08149
30 July 2010

**MODIFICATIONS TO MP 08_0093
DARLING WALK, DARLING HARBOUR**

On behalf of our client, Lend Lease Development, we write to request the Minister (or his delegate) modify the Project Approval 08-0093 under Section 75W of the *Environmental Planning and Assessment Act 1979* as described below. The modification relates to minor changes to the layout and design of the kiosk and shade structures within the Children's Playground area. The following amended kiosk and shade structure drawings are attached:

AMENITIES KIOSK

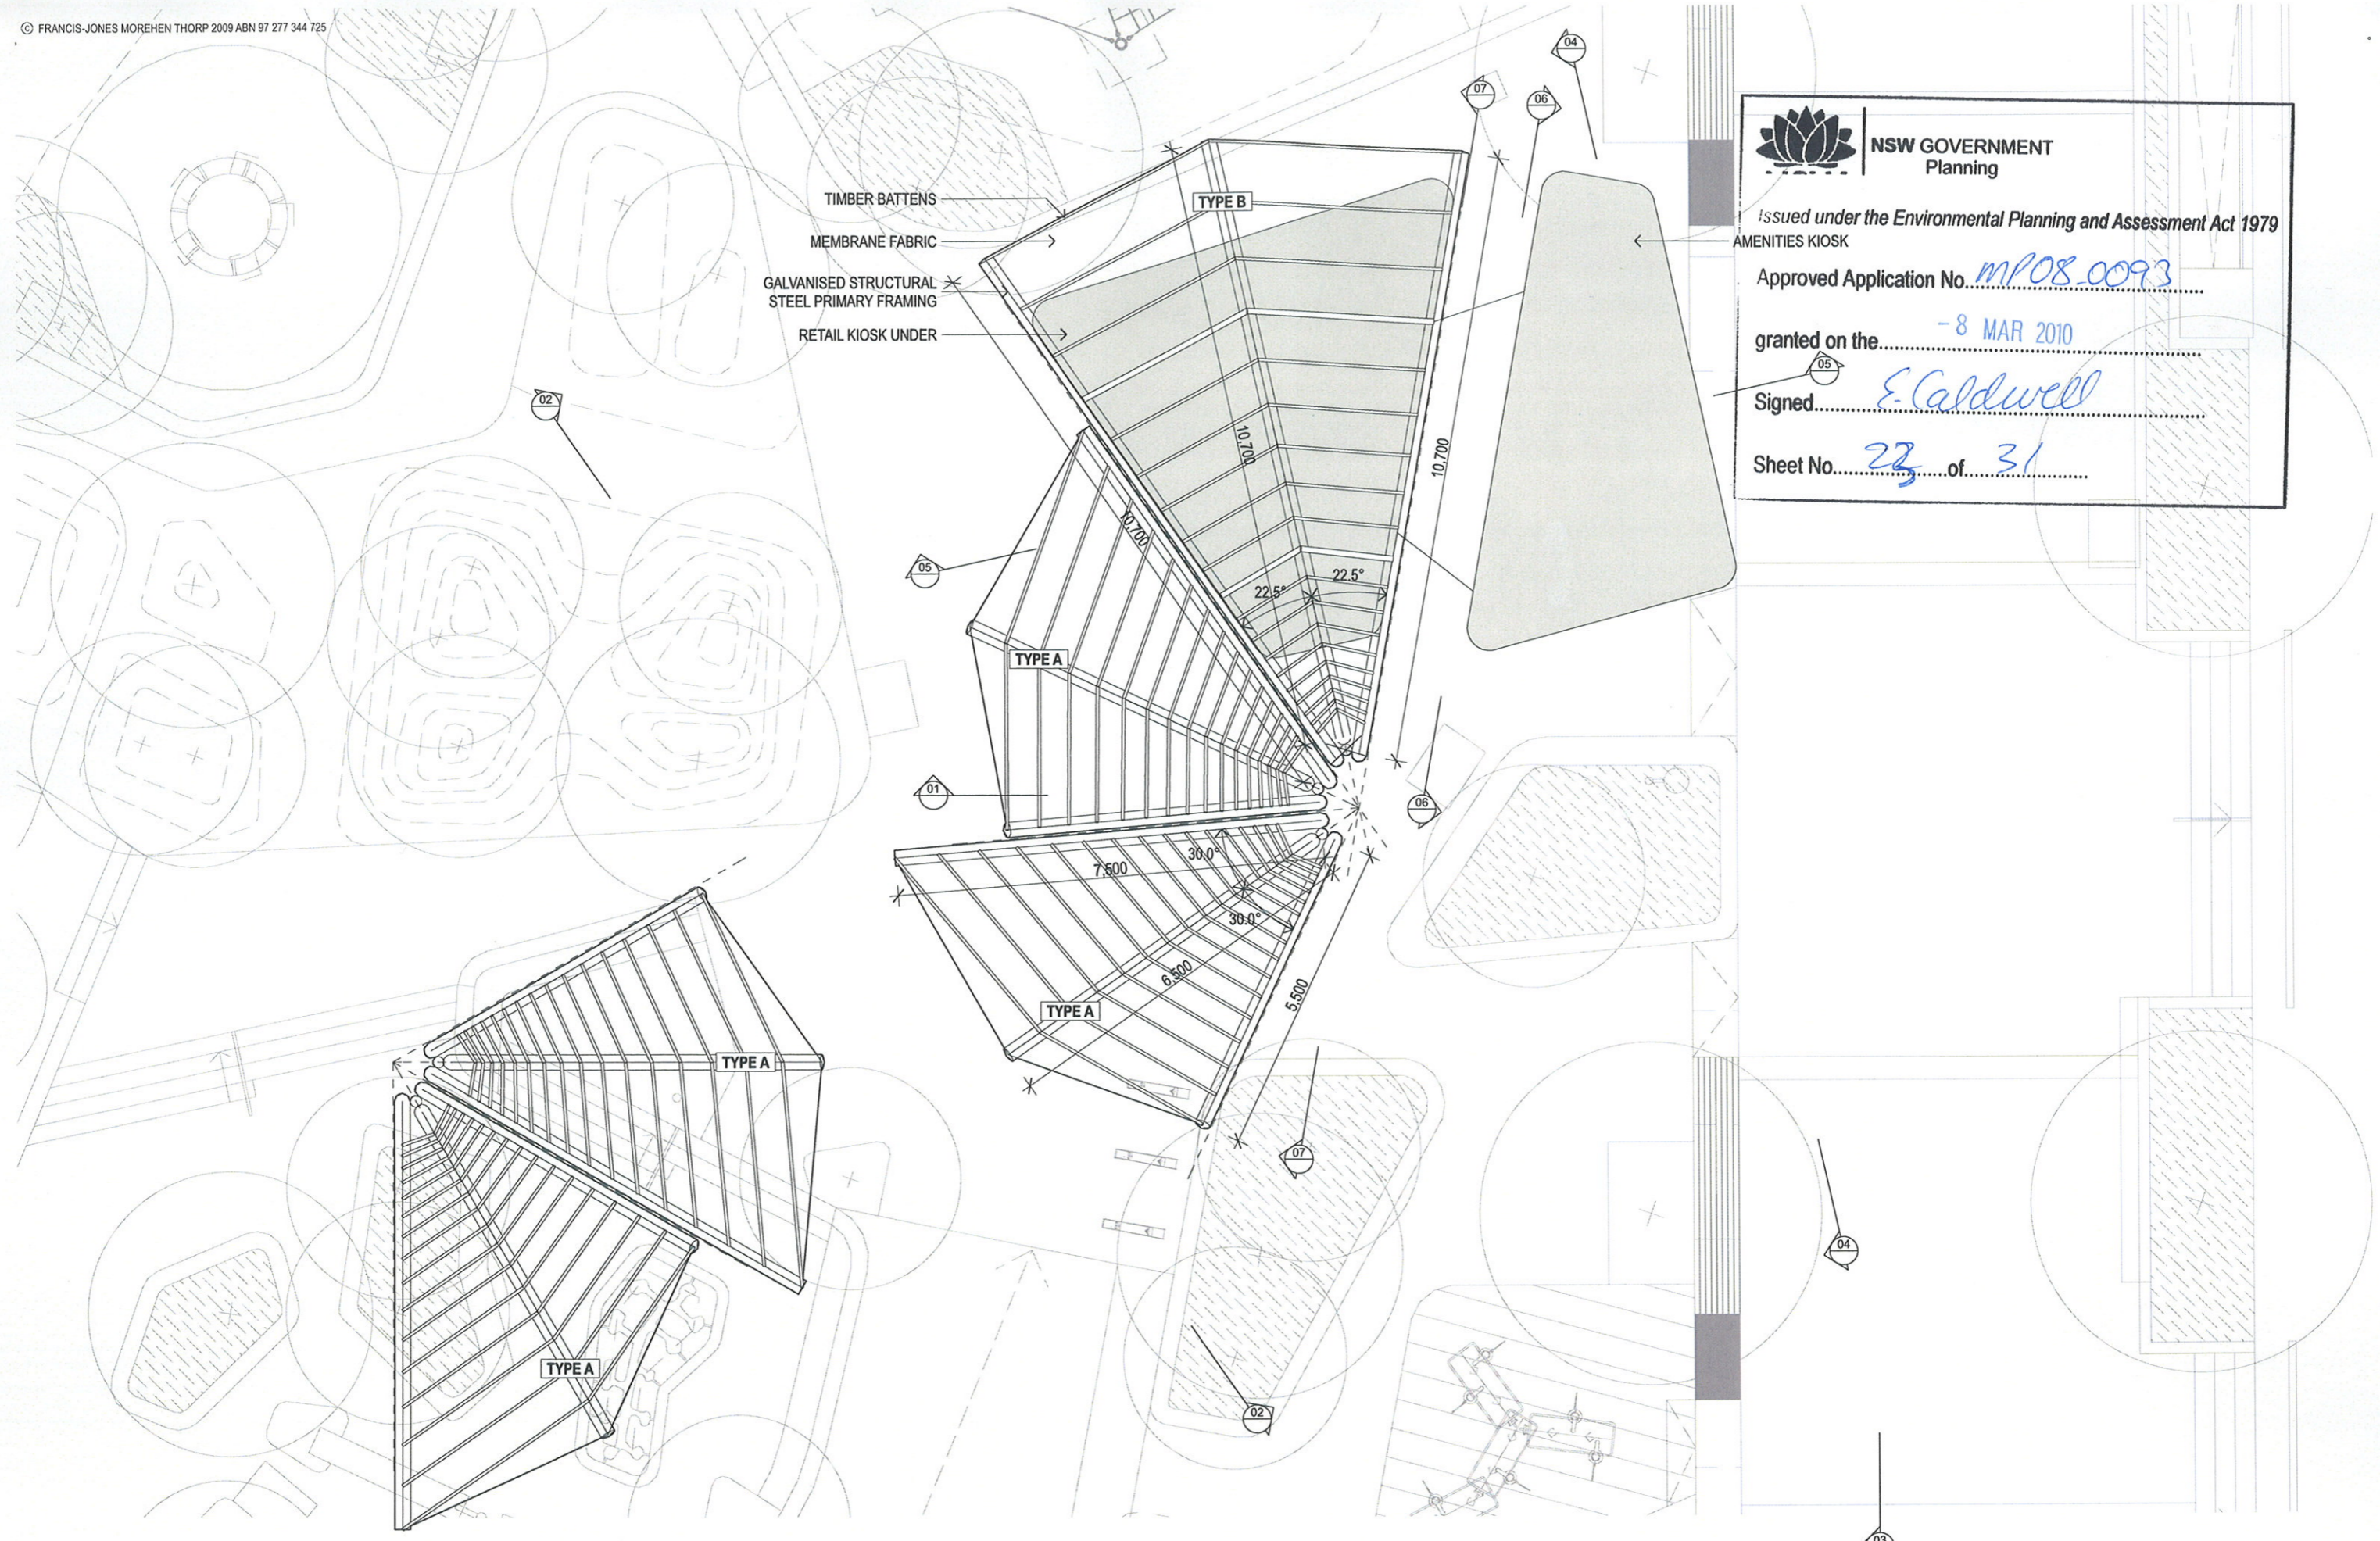
It is proposed to modify the layout and design of the kiosk, amenities block and the shade structures. The current design includes a Kiosk (35m²) and separate amenities building (23m²) on the eastern side of the playground. The amenities included two unisex toilets and one accessible toilet with baby change facilities. The amenities block also provided access to the plant room servicing the water play areas and water features. The shade structures over the kiosk, amenities building and baby and toddler play area were to be made of galvanised steel and aluminium with timber battens spanning between 7m and 9m in length and up to 7.4m in height.

The modifications to the kiosk, amenities building and shade structures comprise:

- reconfiguration of the kiosk building and reduction in area to 30m² GFA;
- reconfiguration and minor reduction in area of amenities building to 20m² GFA to provide one accessible toilet;
- new seating area in front of the amenities block; and
- construction of three separate shade structures to cover the amenities building and seating area, retail kiosk building and associated seating area and baby toddler, sand pit and water play area respectively.
